Office of
Environment
& Heritage

RE: NARAMA WEST OPEN CUT MODIFICATION (PA 09_0176 MOD1), RAVENSWORTH OPERATIONS PROJECT– REVIEW AND REQUEST FOR FURTHER INFORMATION

ASSESSMENT OF THE PROPOSED NARAMA WEST OPEN CUT MINE (PA 09_0176 MOD1) AND RECOMMENDED CONDITIONS OF APPROVAL

Figure 1 – PPV vs Distance

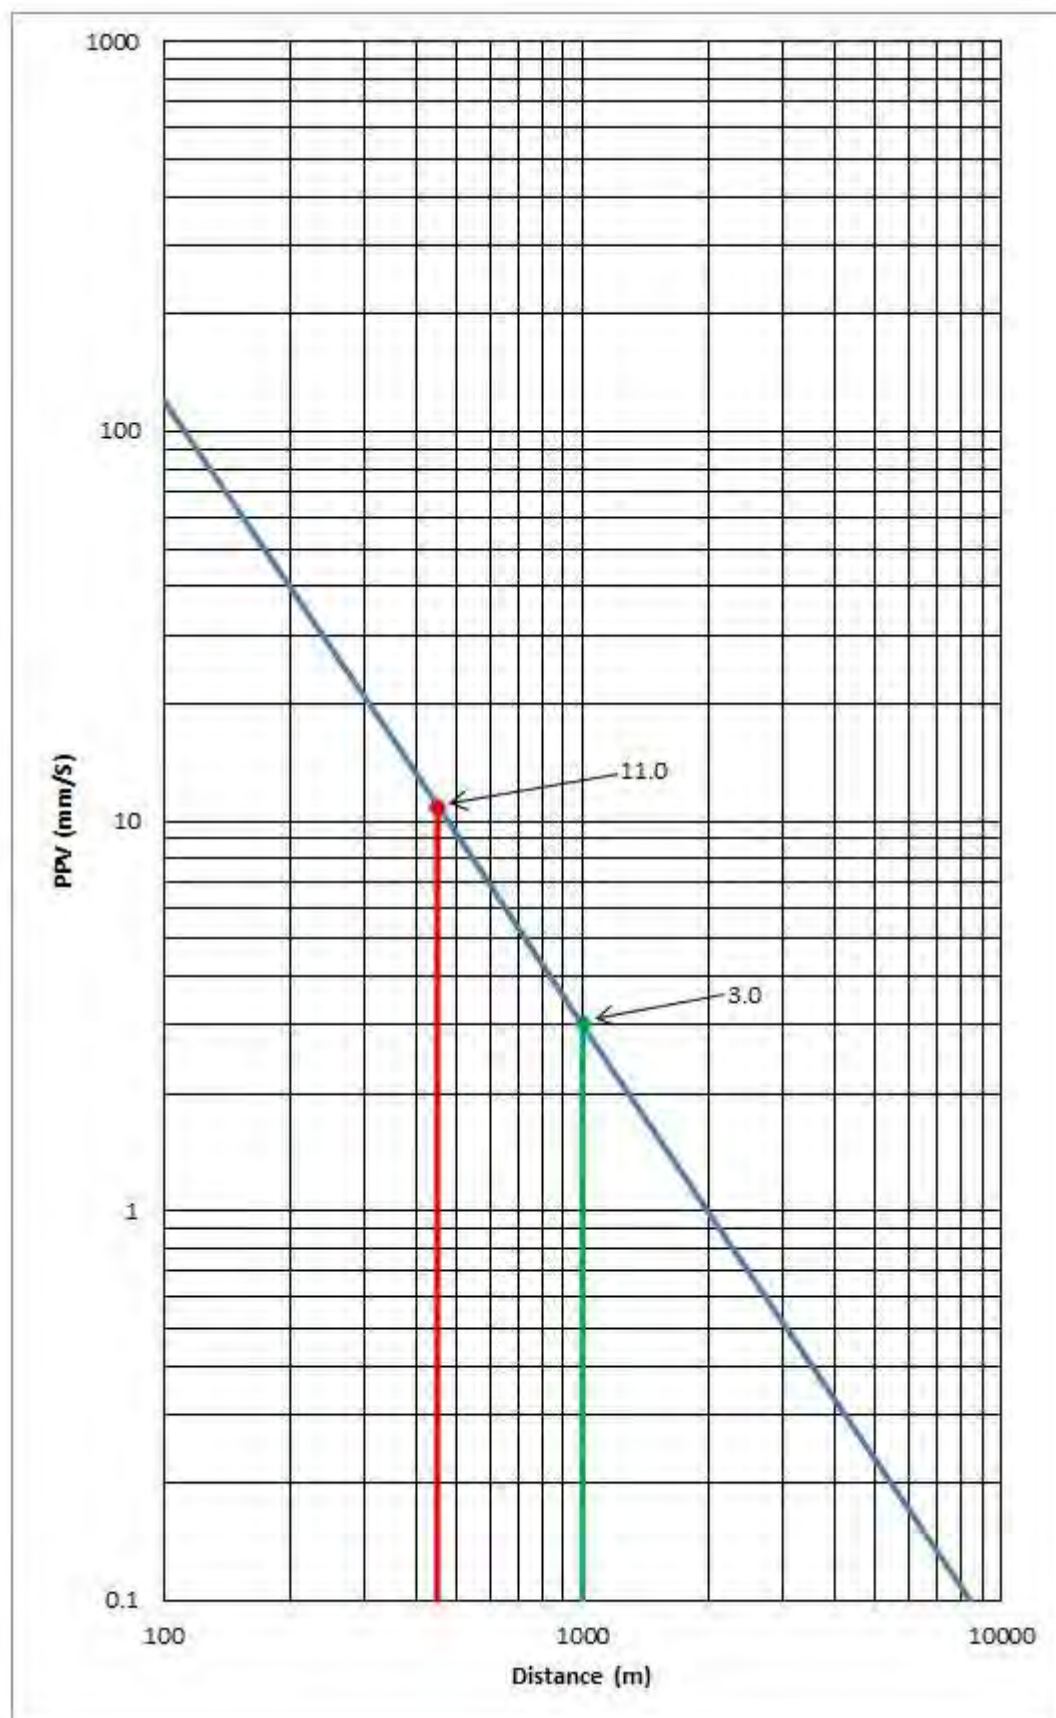
- Editorial matter. OEH refers to Figure 1 of the letter from Terrock Consulting Engineers (dated 19 February 2013). Further information is required by the proponent to clarify the source of the data presented in this figure.

Figure 5: Proposed Amendment to Project Boundary

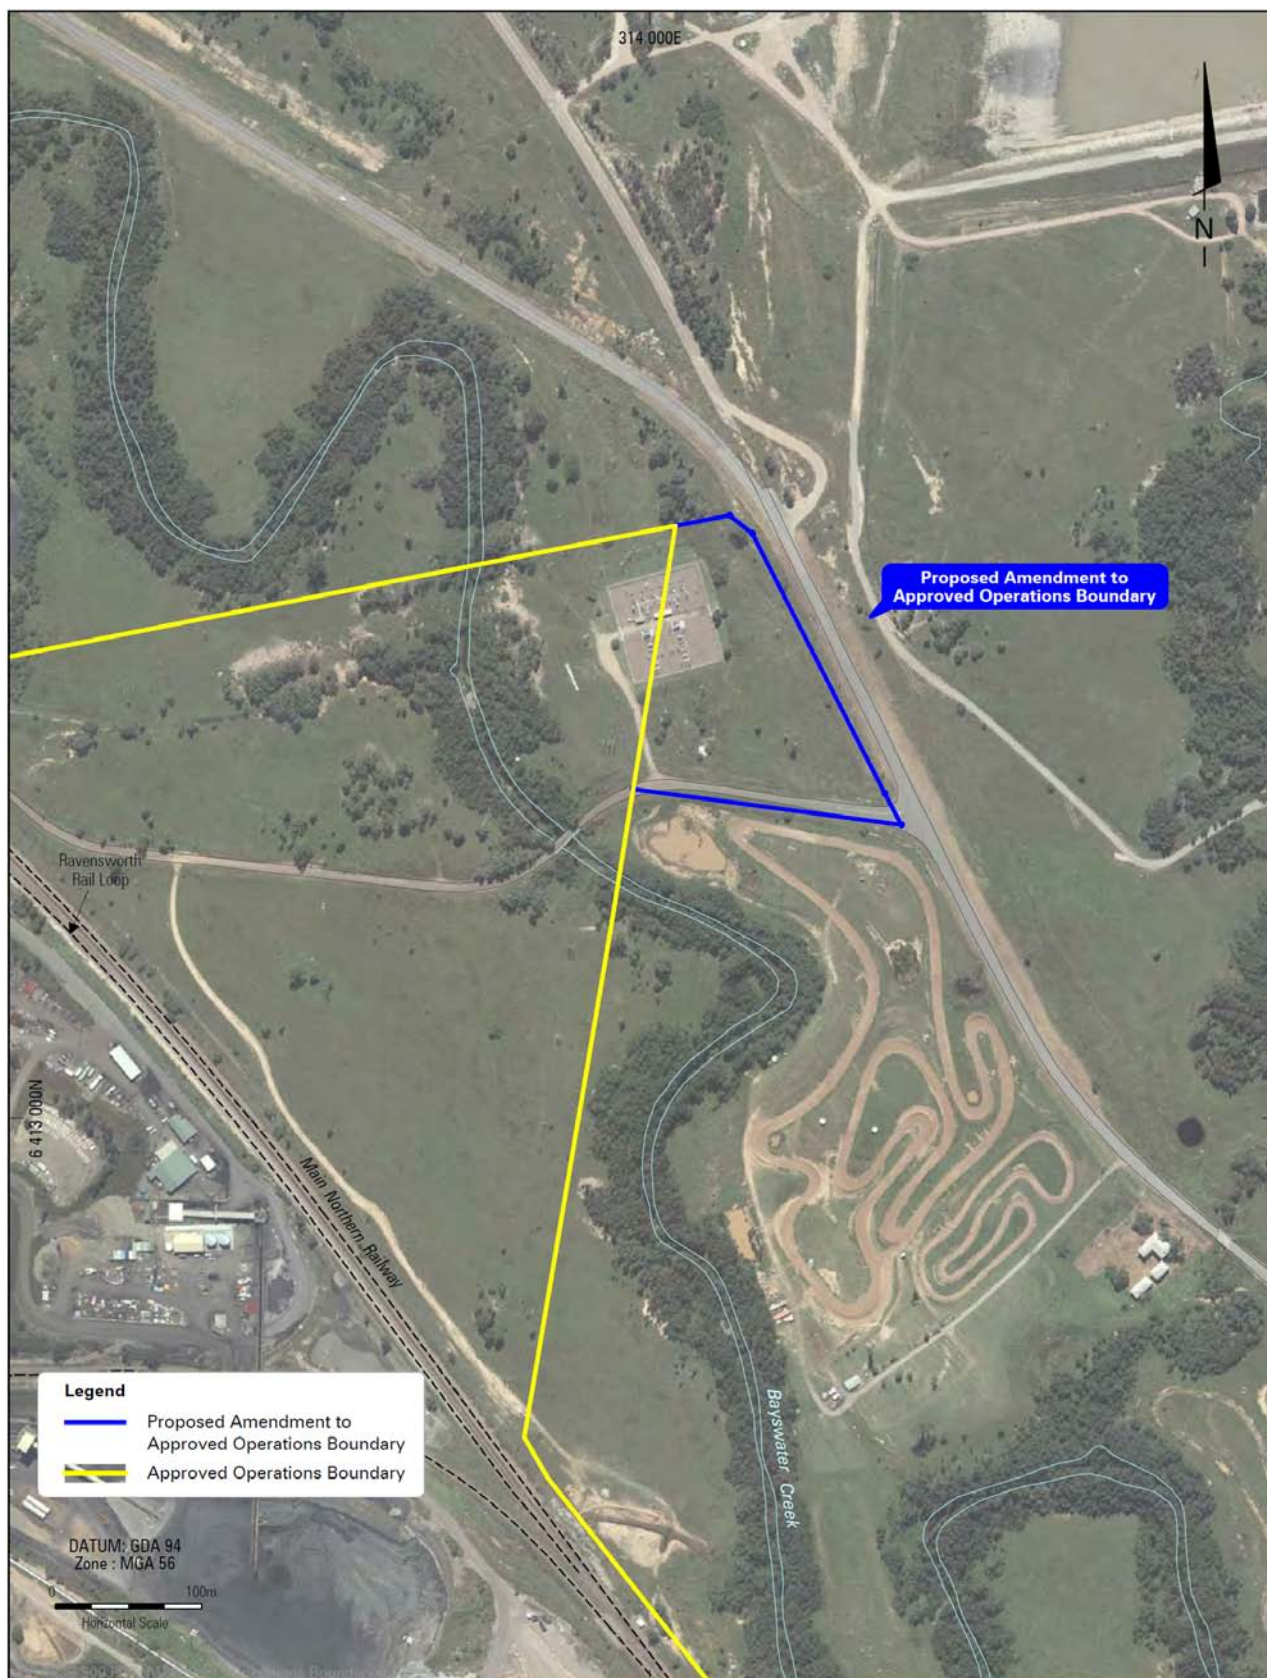
OEH also understands that the proponent committed to investigating this matter further in accordance with the approved ACHMP, in consultation with the Aboriginal community following advice from DP&I (in letter dated 21 August 2012) and prior to any augmentation works being undertaken. However, the current modification proposal has not included any additional details of the investigations undertaken or any of the results obtained in support of this proposal. It is therefore strongly recommended that the proponent provides additional details documenting the Aboriginal cultural heritage values associated with this additional area in support of the proposed development modification. This should include:

- details of any additional Aboriginal cultural heritage investigations undertaken within the proposed amendment to the approved operations boundary
- details of any Aboriginal sites and/or PADs associated with this area
- in the event that any additional development activities likely to occur in this area have the potential to, or, are likely to impact or harm Aboriginal objects, detailed management strategies developed in consultation with the registered Aboriginal parties for this project.

OEH therefore is not in a position to support the proposed amendment to the approved operations boundary until the above matters are addressed by the proponent.
